RE: Bartlett Rezone Amendment – Variance of use and Site Development Plan – 53121-11-005

# Letter of Intent\_v1\_redline.pdf Markup Summary

**ZONE MAP**  
**BARTLETT - CHICAGO AVE.**

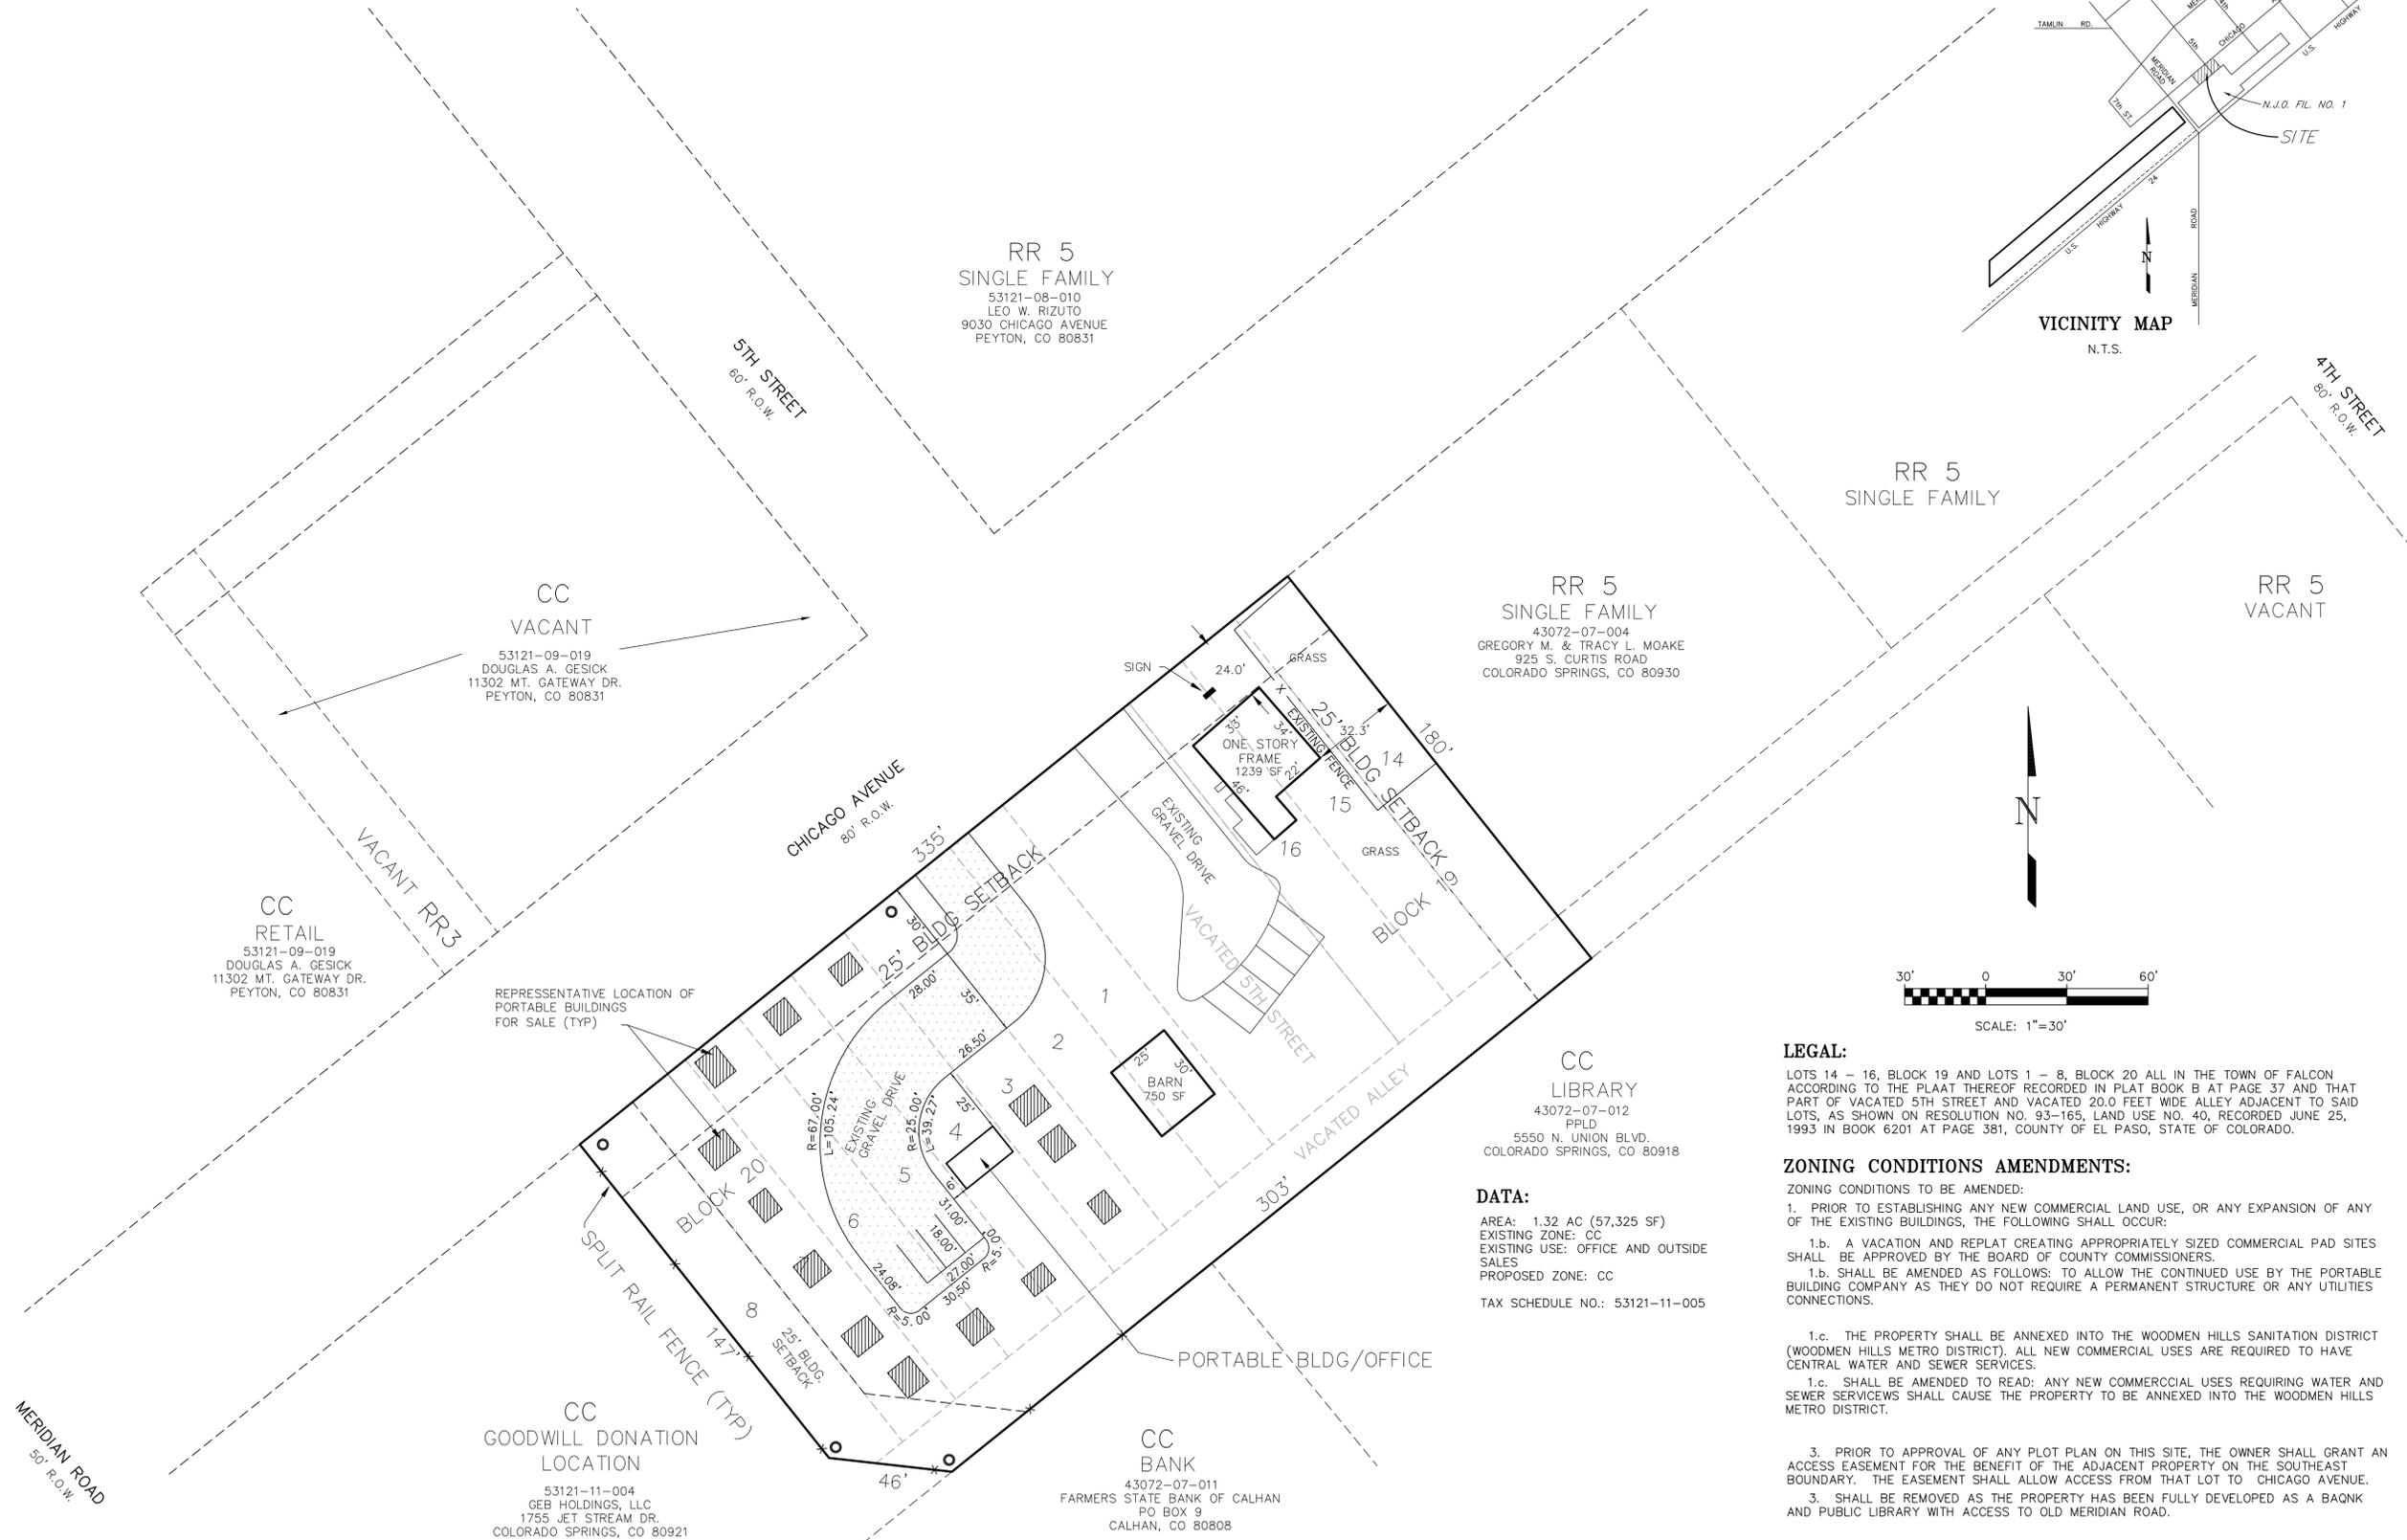
After discussing with the engineering manager, staff would not support the deletion of this easement requirement.
